The Planning Inspectorate  
Temple Quay House  
Temple Quay  
Bristol  
BS1 6PN

**TR010060 - A12 Chelmsford to A120 Widening Scheme - Gershwin Boulevard Bridge**

In reviewing the numerous documents released in relation to Deadline 3, one of these is document reference **TR010060/EXAM/9.26 - TECHNICAL NOTE GERSHWIN BOULEVARD BRIDGE**. It is clear that National Highways and/or their contractors have had the opportunity to review my submissions and those of several of my neighbours in relation to the proposed bridge located adjacent to Olivers Drive and Halfacres in Witham, in order to produce this extensive document. It is only fair that I, and others if they wish to do so, have the opportunity to respond to this technical note, which I believe to be significantly flawed.

VIEWPOINT 2: Representative view west from PRoW 213_45 on Paynes Lane, Boreham

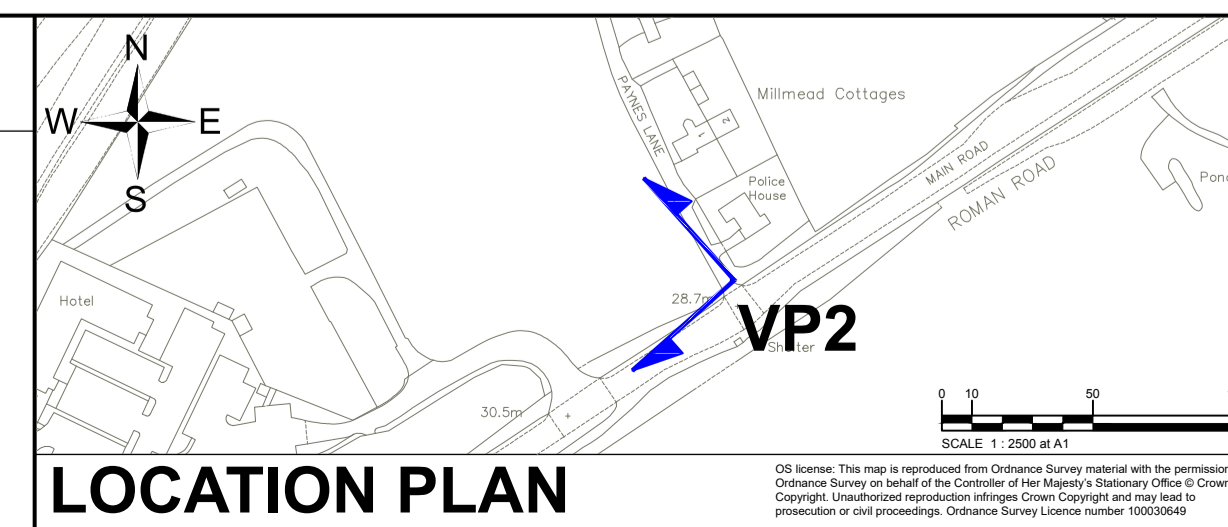
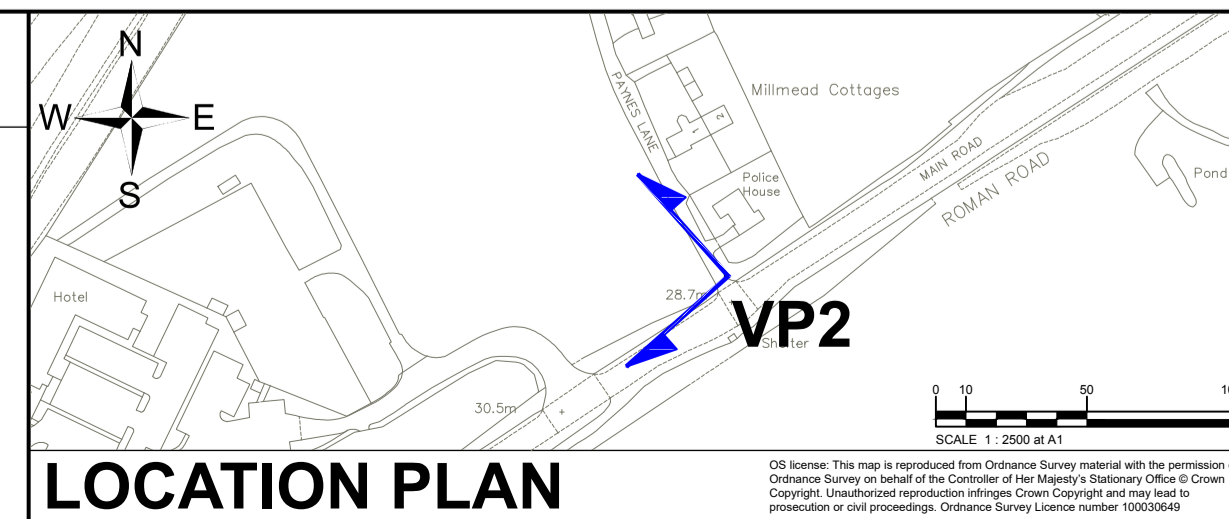
Although images are included in the document (Viewpoints 2 and 4), these clauses only consider the impact on properties to the North of the A12. Under National Highways' proposed location there would also be a detrimental impact on approximately twenty properties on the Western side of Maldon Road to the South of the A12. However the proposed alternative location is adjacent to a minor road (Viewpoint A) that provides access to an electricity sub-station, and to one commercial and one residential premises that both lie around 400 metres west of the location and less than 50 metres from the A12 so much less of an overall impact than the original proposed location.

There is no equivalent analysis for viewpoints A and B. If there were to be such an analysis conducted, the impact at Viewpoint A would be considerably less than at viewpoints 2 and 4 due to the functional location of Howbridge Hall Road and this location not being a public amenity.

VIEWPOINT 3: Representative view from Centenary Circle long distance path (PRoW 234_17) where it meets PRoW 234_18, within the Chelmer and Blackwater Navigation Conservation Area

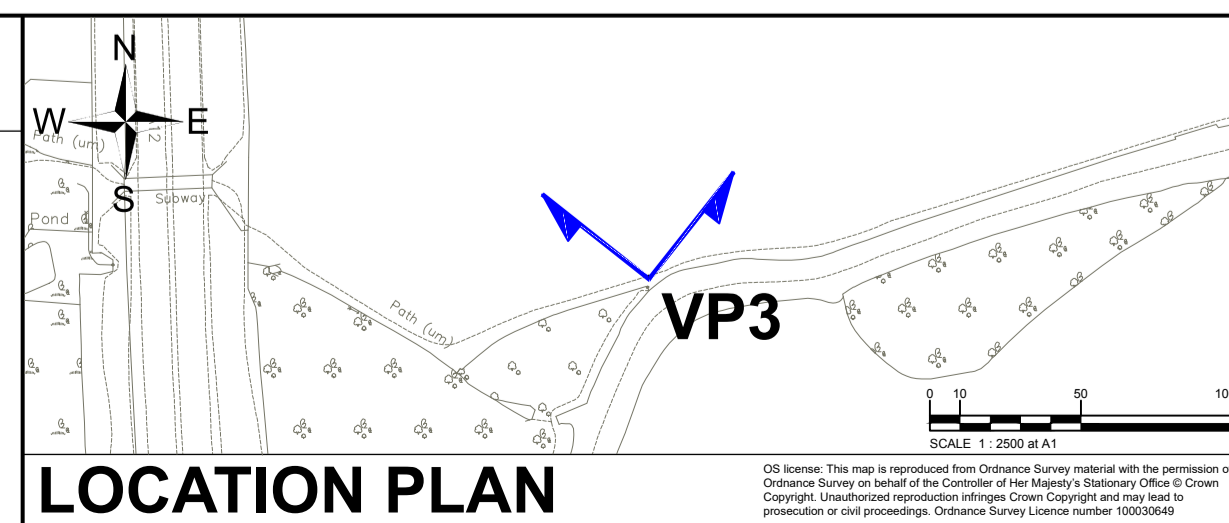
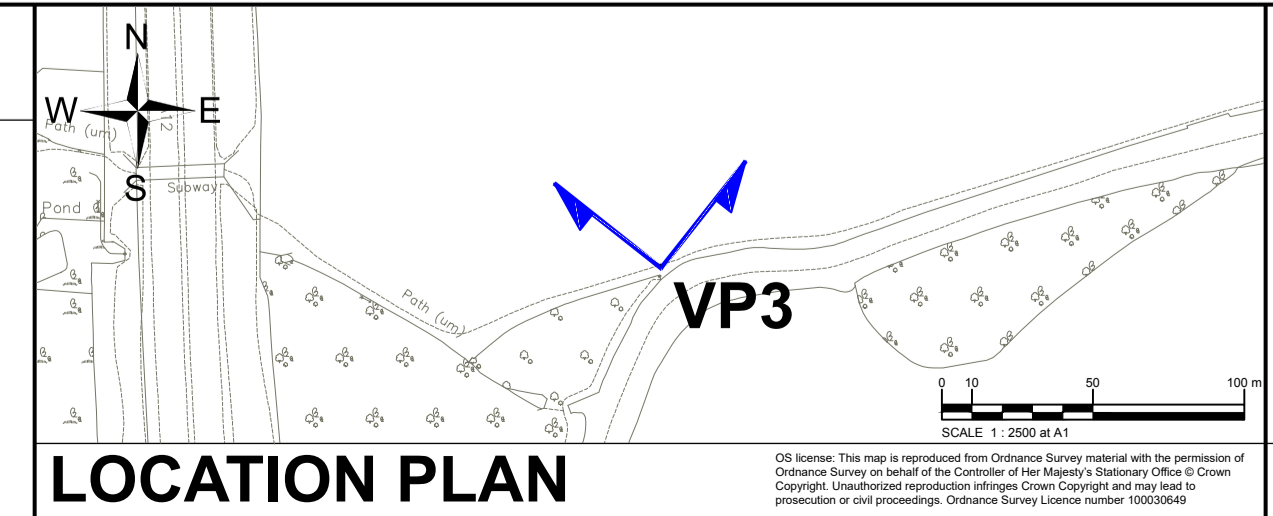
The appendix takes 16 pages to describe in detail that the impact of the construction at viewpoints 1 to 4 will be severely impacted at construction and year 1 reducing to moderate adverse at year 15. However, a bridge at the proposed location would be prominently located at the top of a sloping grass field (Viewpoints 1 and 3) so the long term impact has to be more than "moderate".

VIEWPOINT B: Illustrative view north from PRoW 90_20, adjacent to Hatfield Priory Registered Park and Garden

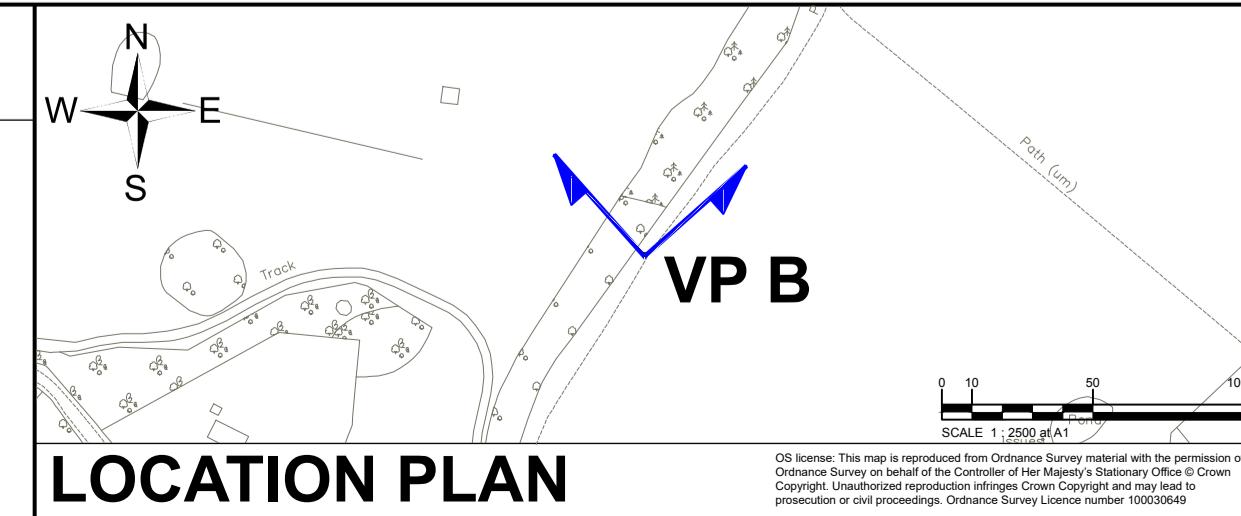
Clause 3.4.1 - The residents that would be visually impacted by the proposed alternative location are at least double the distance from the location than those who would be impacted by the original proposed location. That distance is characterised by a drainage lake and a busy spine road (Gershwin Boulevard) - Viewpoint B in the Technical Note.

*Image 5 - Viewpoint B from the Technical Note - showing the approximate location of Howbridge Hall Road beyond the A12 which is the proposed alternative location and not where indicated by National Highways' blue arrow.*

Similarly, at Viewpoint B, the proposed alternative location is separated from the Viewpoint by a drainage lake surrounded by a metal railing fence, a busy 40mph road, and a much greater distance. This could be further mitigated by the design of the access ramp, which could potentially be aligned as a continuation of the bridge line rather than parallel with the A12 and run alongside the retained vegetation at this point. This would also address the concern submitted by Braintree District Council in their response also release with the Deadline 3 submissions.
